October 16, 2020

Re: StarBucks
8721 Washington NE
Traffic Circulation Layout
Architect's Stamp 10-15-2020 (C17-D128)

Based upon the information provided in your submittal received 10-15-2020, the above referenced plan cannot be approved for Building Permit until the following comments are addressed:

B1 'ONE WAY' FACE DETAIL  
SCALE: NTS

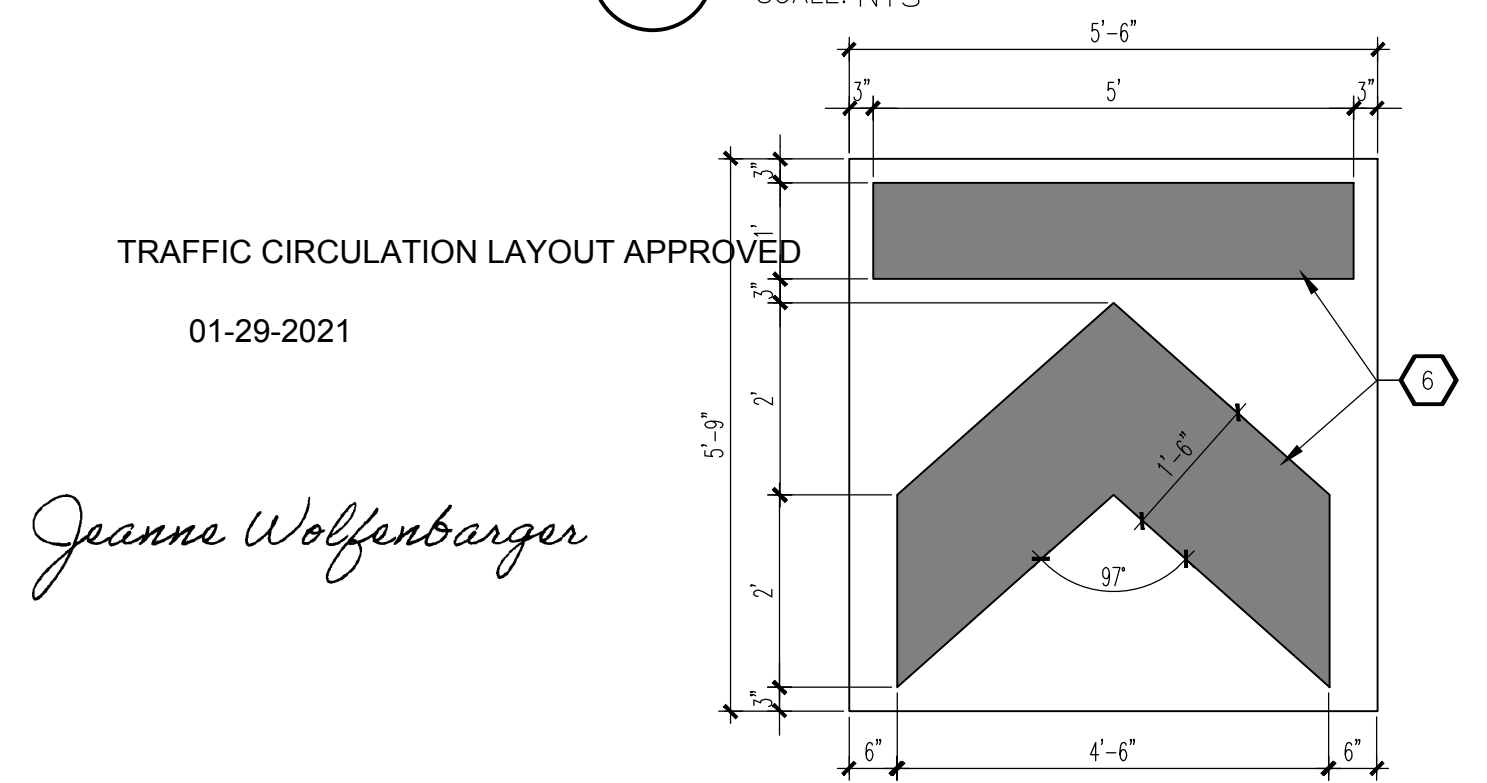
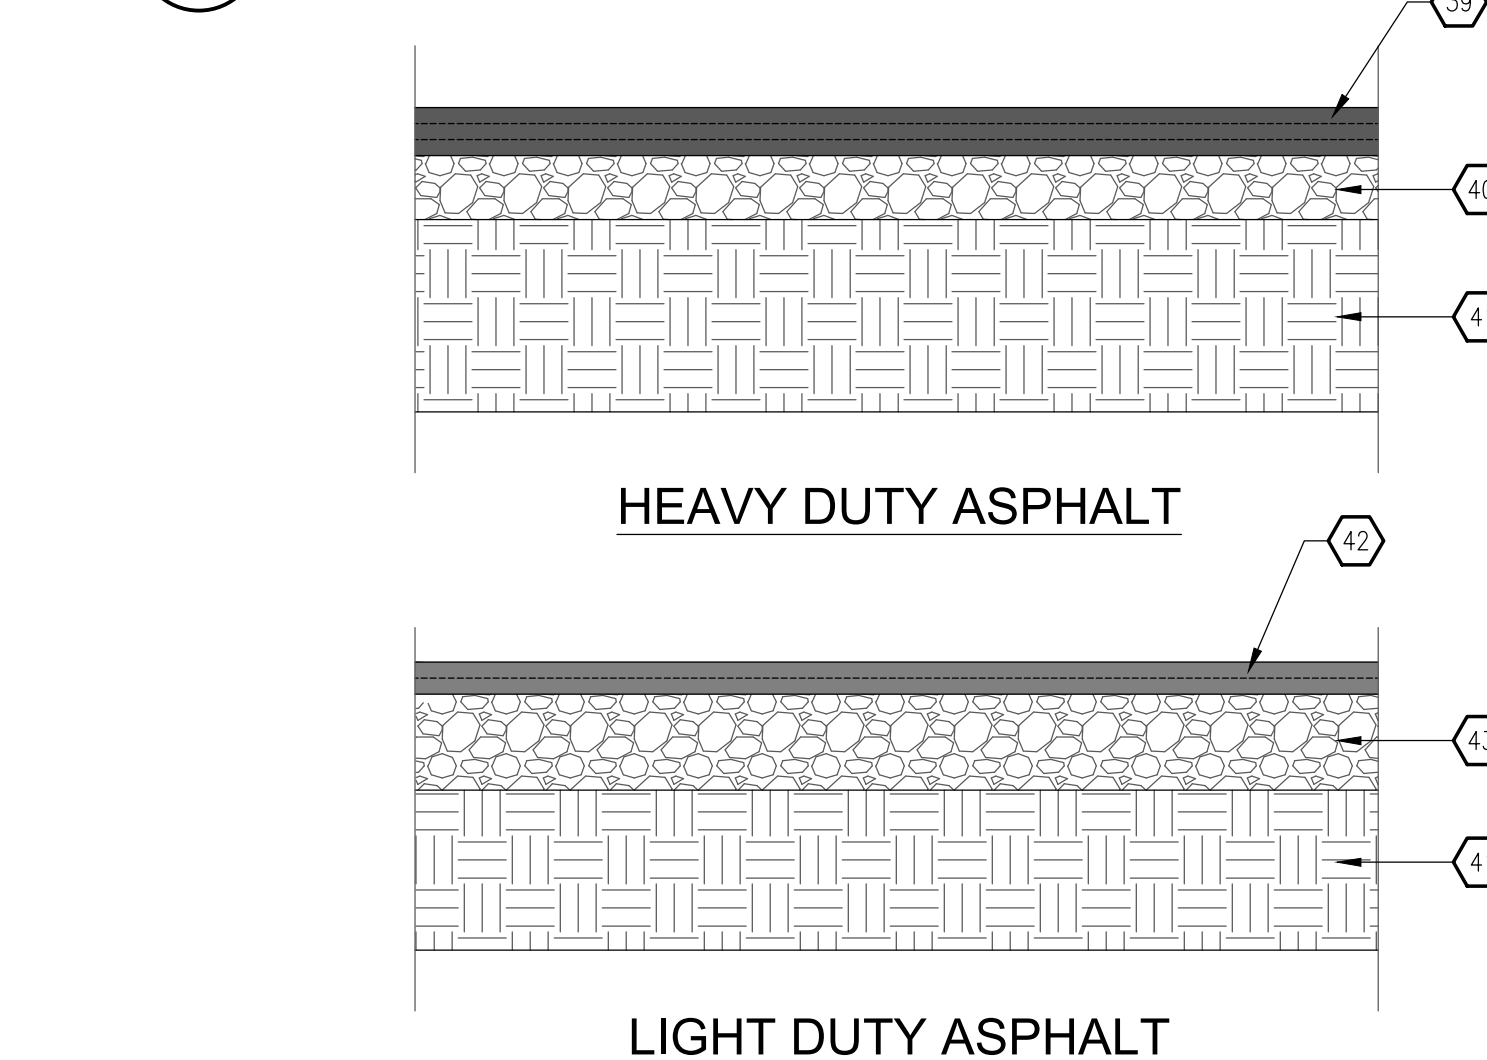
13. All sidewalks along Alameda Blvd and Washington St should be placed at the property line.
 14. Provide a copy of refuse approval.
 15. All one-way drives shall have **"One Way"** and "Do Not Enter" **signage** and pavement markings. Please show detail and location of posted signs and striping.

A3 ARCHITECTURAL SITE PLAN  
SCALE: 1:20

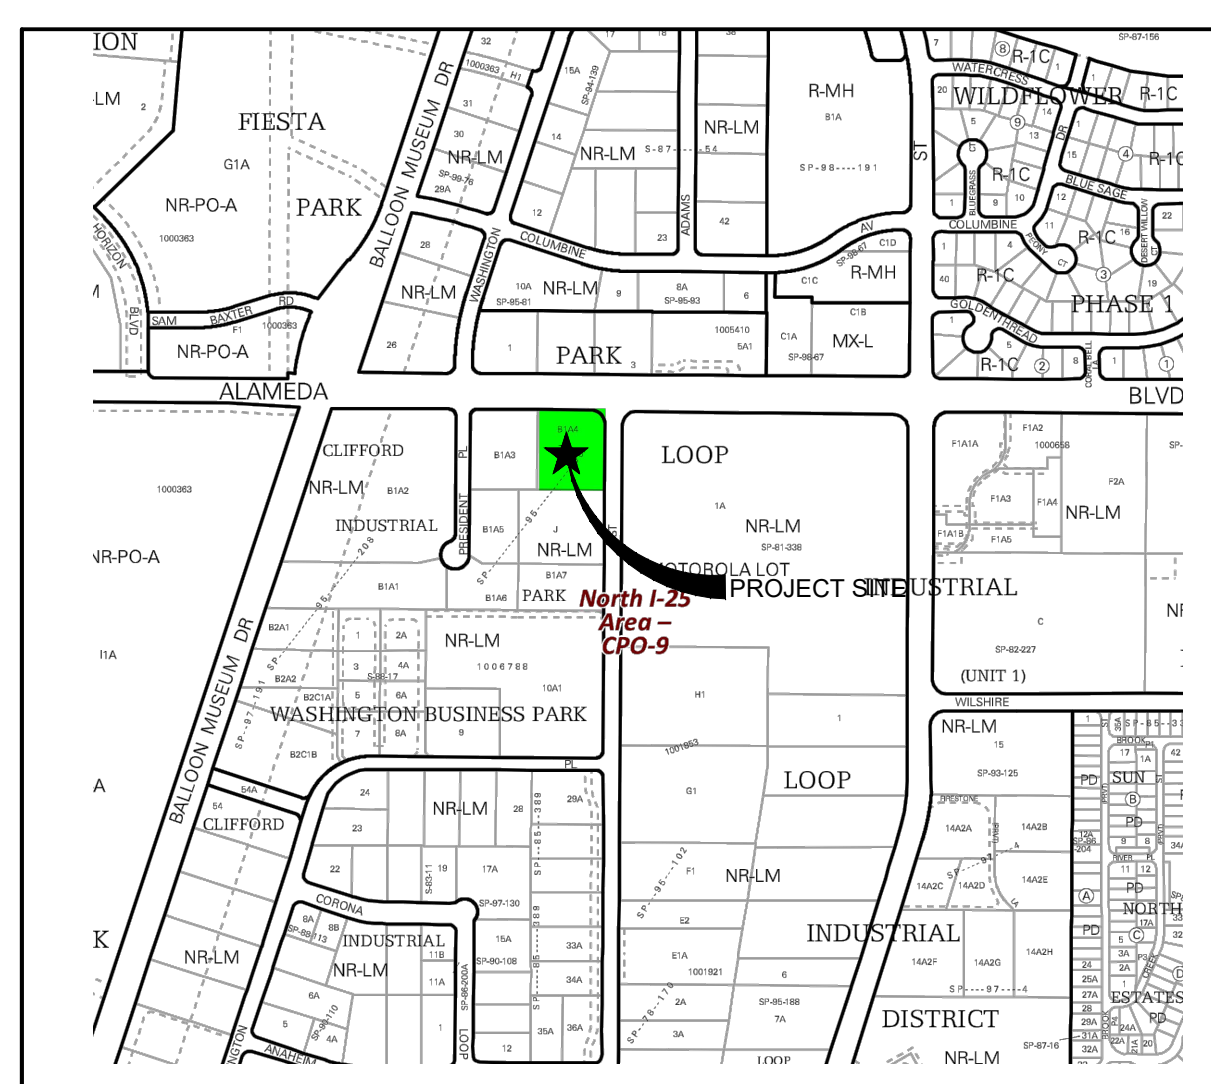
1. **Please show a vicinity map showing the location of the development in relation to streets and well known landmarks.**
2. **The listed number of parking spaces required by the zoning code as well as the proposed number of parking spaces including bicycle and motorcycle parking. All proposed required calculations need to be discussed with Zoning.**

3. **Please make sure your throat depth is appropriate for the proposed entrance drive off Washington St (See DPM for criteria).**
4. **Identify all existing access easements and rights of way width dimensions.**

5. **ADA parking stalls overhang might have a conflict with proposed ADA signage. Please clarify this concern.**
6. **ADA curb ramps must be updated to current standards and have truncated domes installed on Alameda Blvd and Washington St.**

NM 87103

10. A 1-foot clear zone around the bicycle parking stall shall be provided.
 11. Bicycle parking spaces shall be at least 6 feet long and 2 feet wide.
 12. Radius for delivery trucks, fire trucks, etc. is 25 ft. or larger.

16. Please provide a sightline distance (Washington St and Alameda Blvd) exhibit and one for landscaping as well.
 17. Show the clear sight triangle and add the following note to the plan:
"Landscaping and signage will not interfere with clear sight requirements. Therefore, signs, walls, trees, and shrubbery between 3 and 8 feet tall (as measured from the gutter pan) will not be acceptable in the clear sight triangle.

18. Please specify the City Standard Drawing Number when applicable.
 19. Shared Site access: driveways that straddle property lines, or are entirely on one property but are to be used by another property, shall have an access easement. Please include a copy of your shared access agreement with the adjacent property owner.

**B1** BIKE RACK  
SCALE: 1/2" = 1'-0"

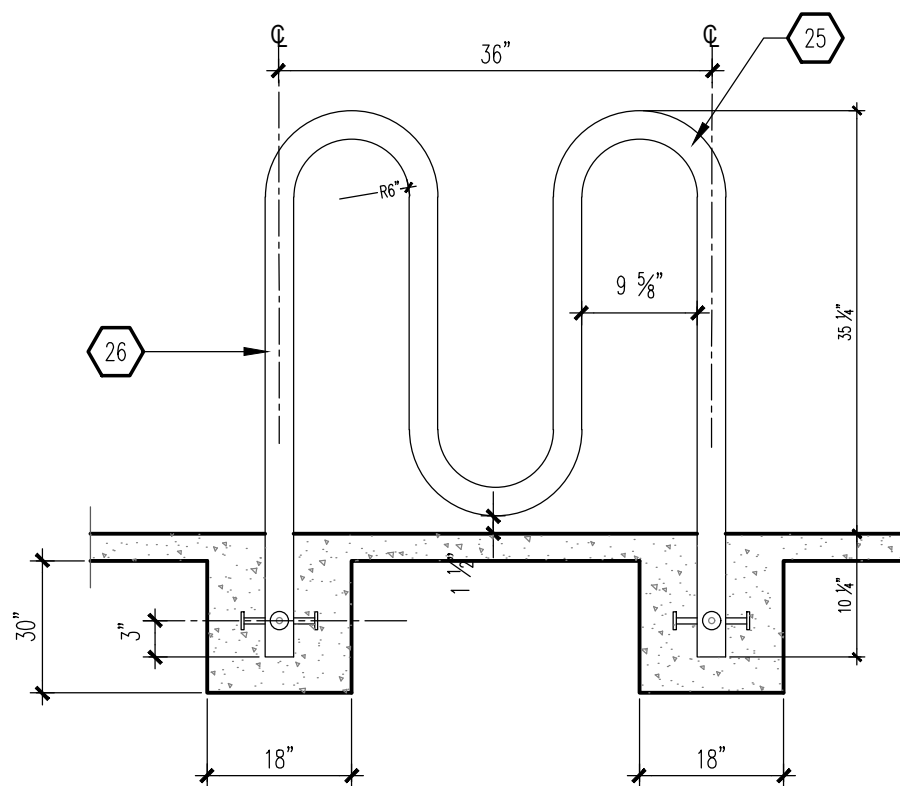
7. **Motorcycle parking spaces: Label pavement MC (If applicable).**
8. **All bicycle racks shall be designed according to the following guidelines:**
 - a. **The rack shall be a minimum 30 inches tall and 18 inches wide.**

- b. **The bicycle frame shall be supported horizontally at two or more places. Comb/toaster racks are not allowed.**
 - c. **The rack shall be designed to support the bicycle in an upright position. See the IDO for additional information.**

- d. **The rack allows varying bicycle frame sizes and styles to be attached.**

- e. The user is not required to lift the bicycle onto the bicycle rack.
 - f. Each bicycle parking space is accessible without moving another bicycle.
9. Bicycle racks shall be sturdy and anchored to a concrete pad.
